Our Ref: 26117/1

Re: Lead Local Flood Authority Response
Land off Chatburn Road Clitheroe BB7 4JX Ref: 3/2026/0315

We write to you in reference to the Lead Local Flood Authority (LLFA) feedback, dated 24/06/2026, received on your planning application on the land off Chatburn Road, Clitheroe, BB7 4JX. The LLFA have objected to the development on the grounds of inadequate surface water sustainable drainage strategy. For ease of comparison we have broken down our response on a point by point basis to match the feedback received.

DRAINAGE LAYOUT
SHEET 2

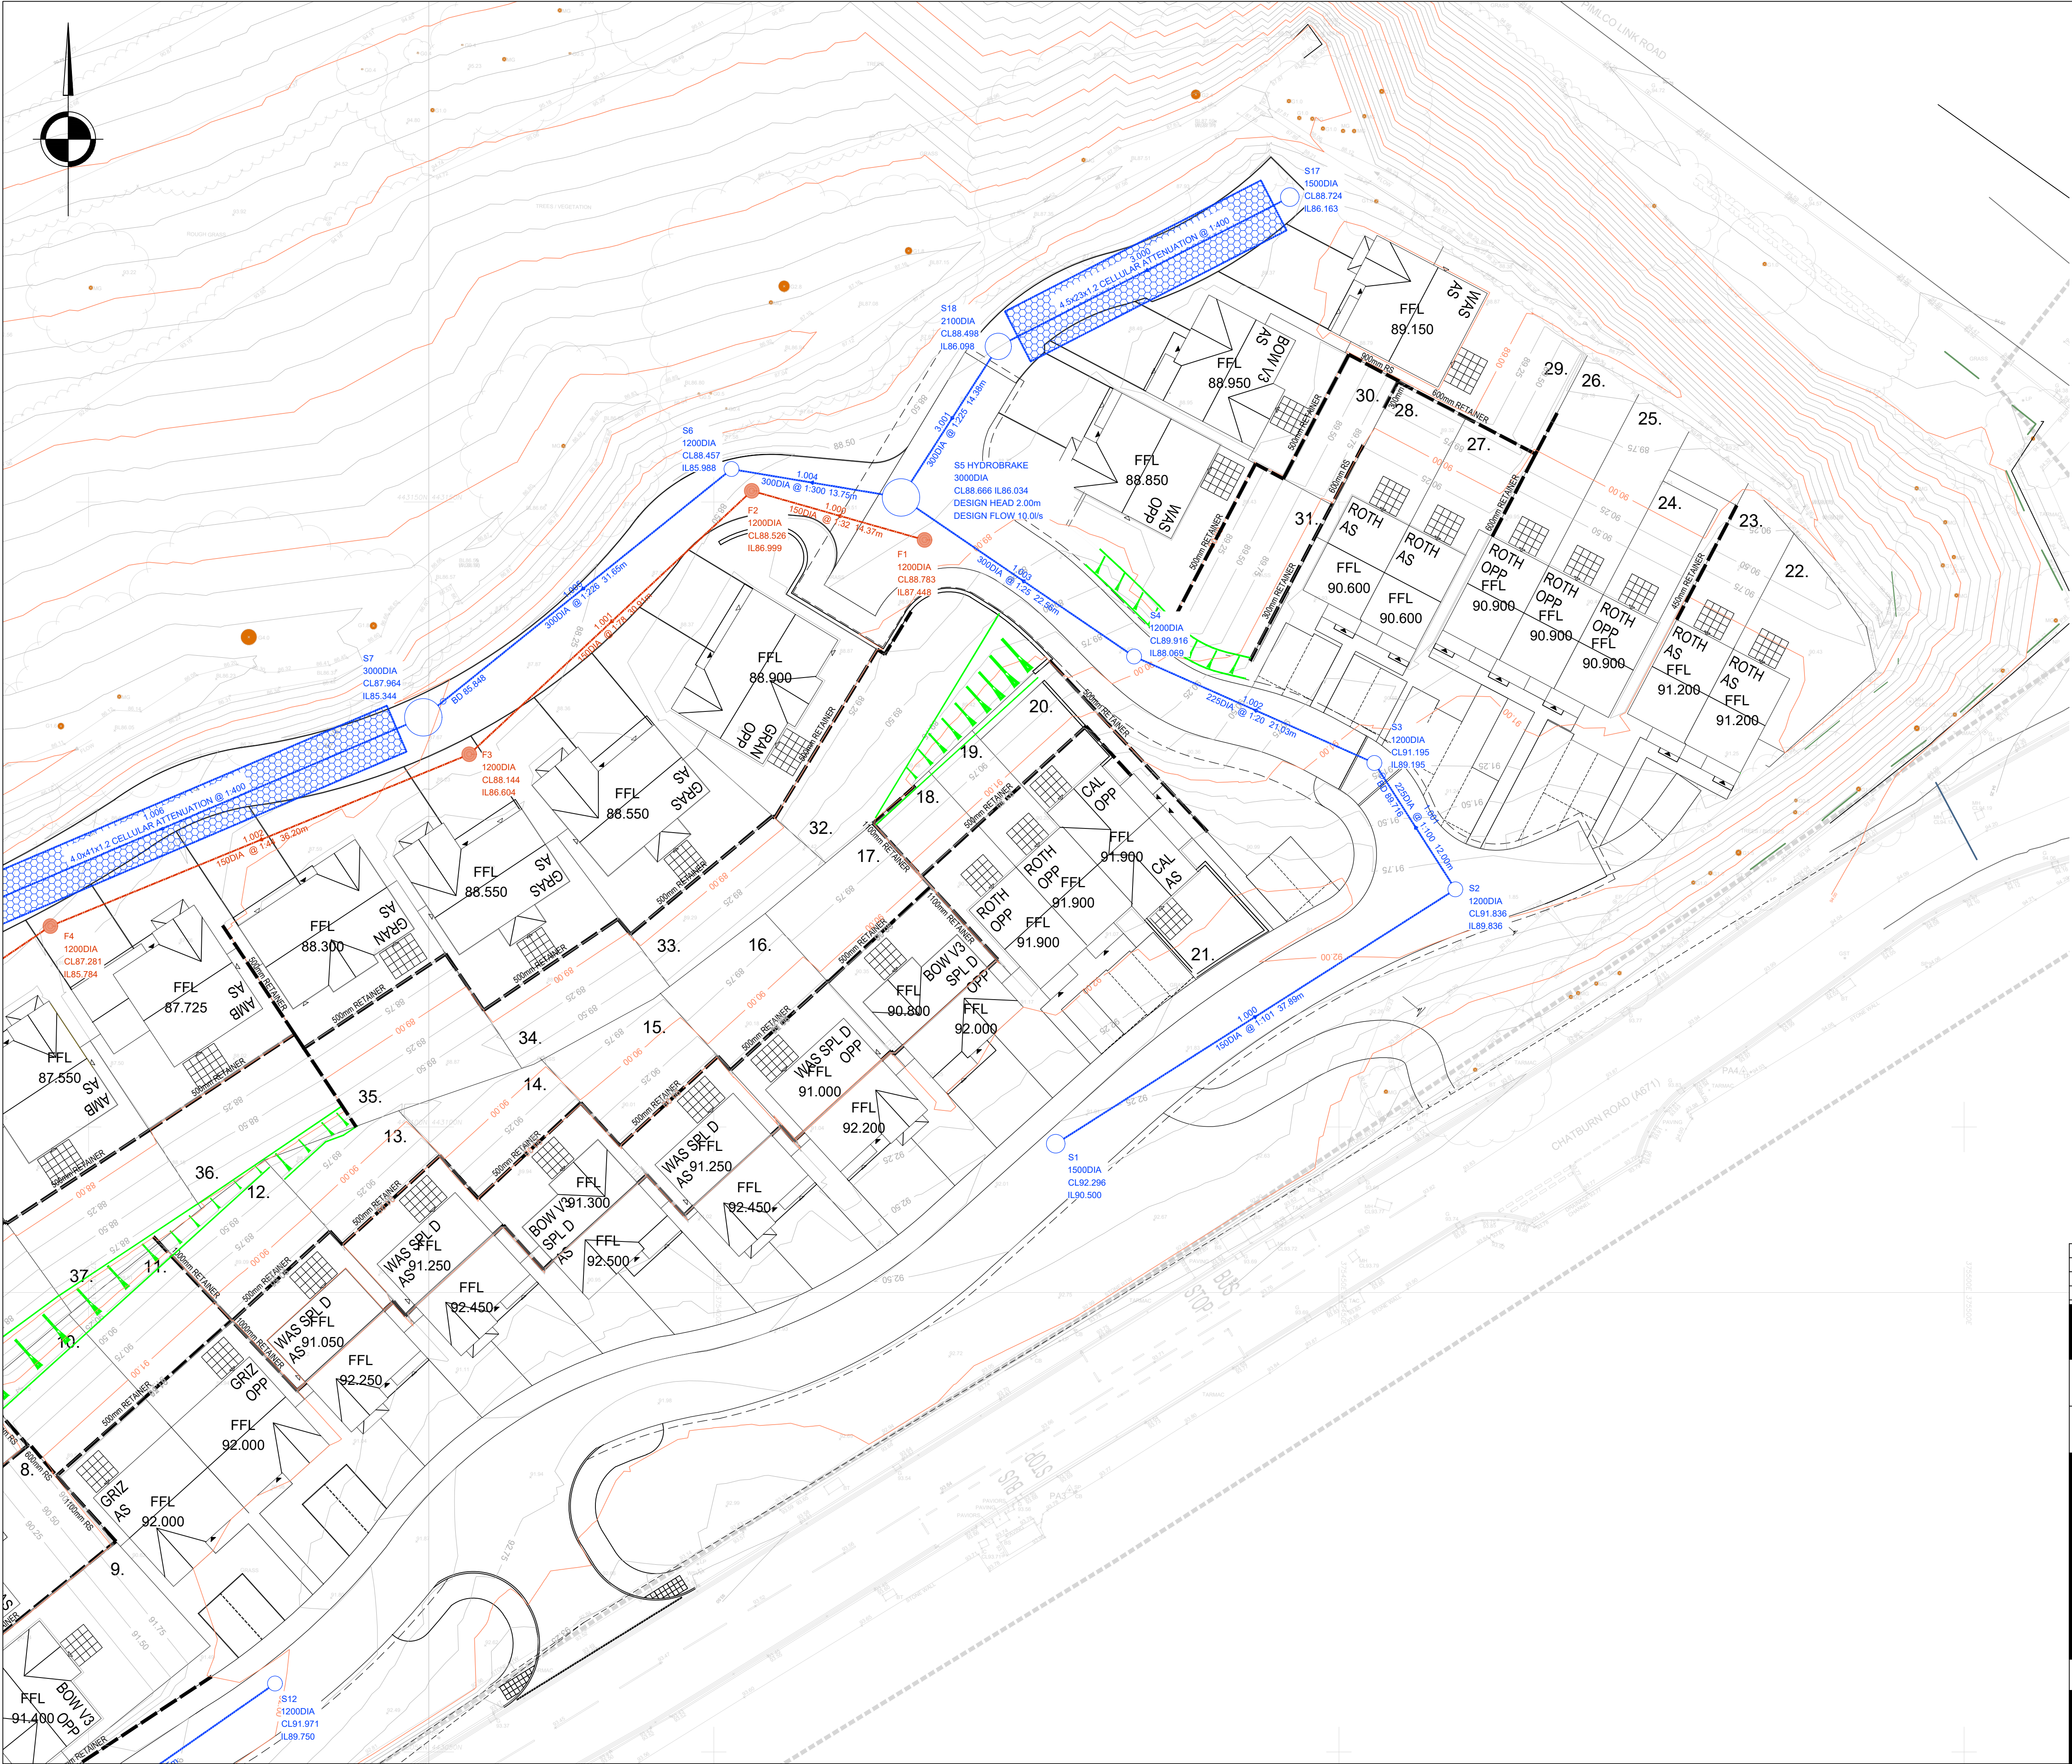
5. Failure to Manage Everyday Rainfall

The drainage strategy has now been updated to satisfy National Standards for Sustainable Drainage Systems; Standard 2. This is achieved through the following methods

With the original design the only SUDS feature that run-off from the roads and footpaths flowed through was the wetland area. We have 2961m² of roads and footpaths on the development and 20% of the equivalent area needs to be provided in the SUDS feature to comply with the standard. We have now increased the wetland area to being 690m² and thus the strategy now complies with the standard.
